**MRGCD Engineering/Mapping Plat Reviews**

PLAT OF
TRACT 1A-1A
MUELLER INDUSTRIAL SUBDIVISION

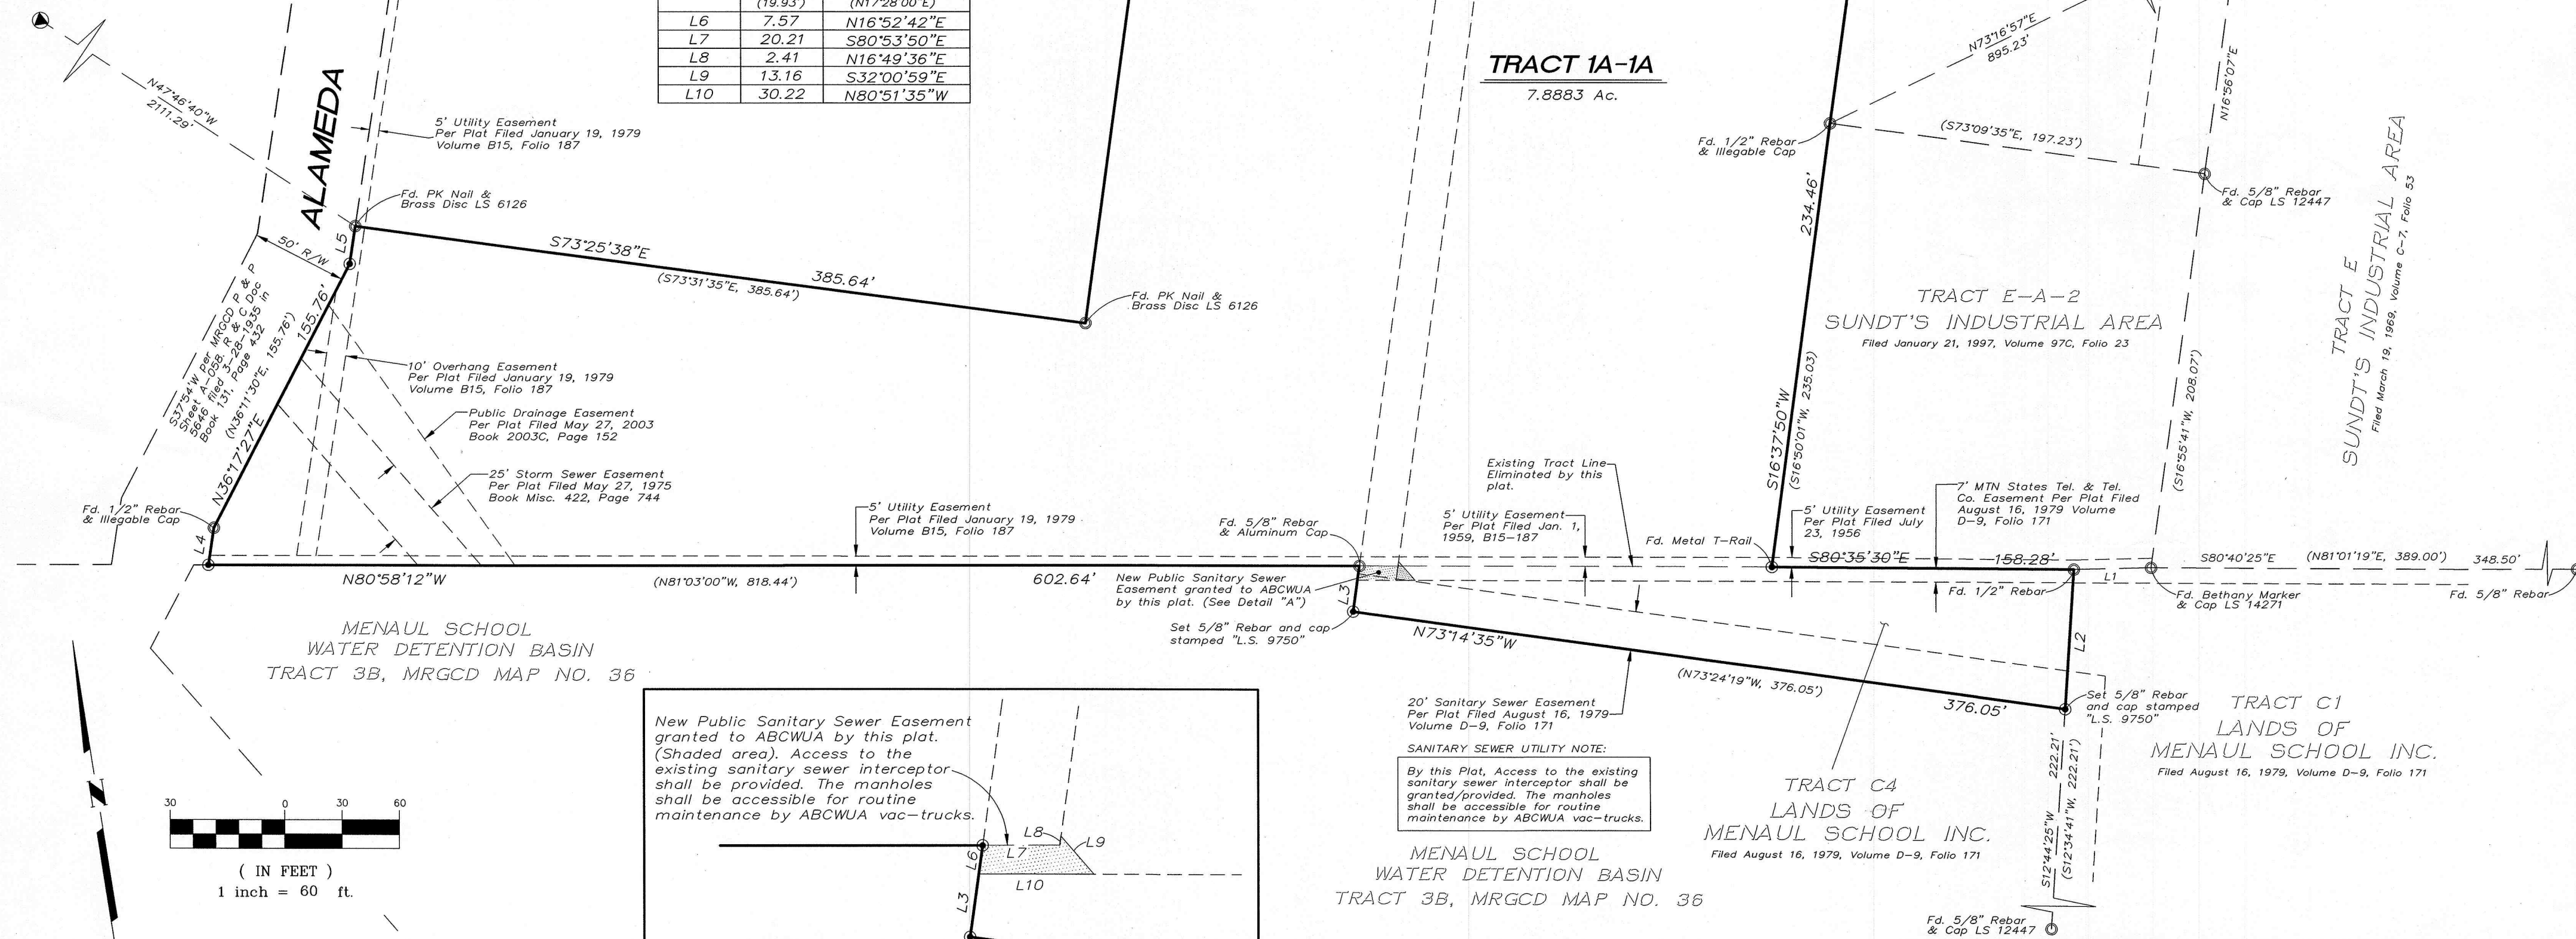
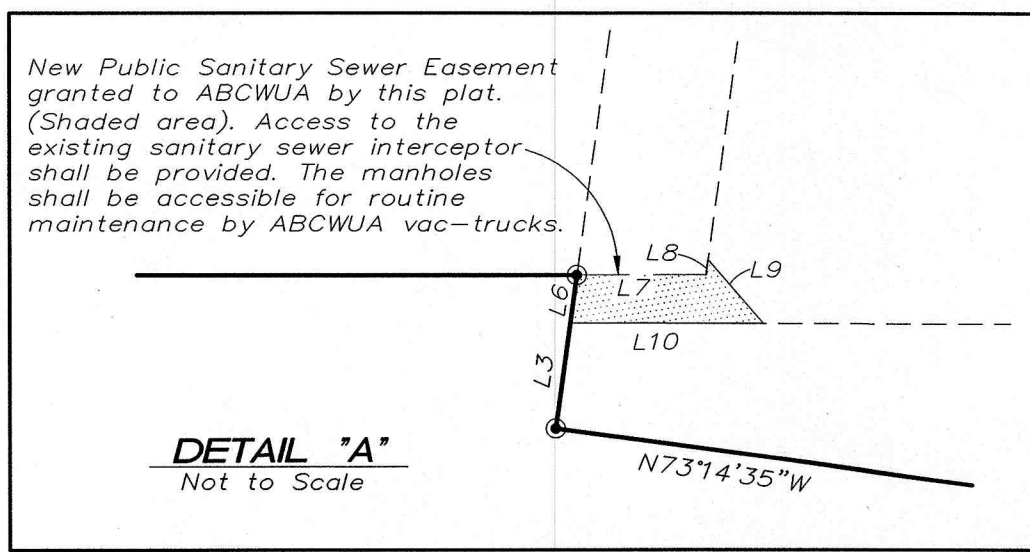
- 1. Please add MRGCD R/W information to match MRGCD records.
  - 2. Final Plat Approval Signature required by the MRGCD.
-
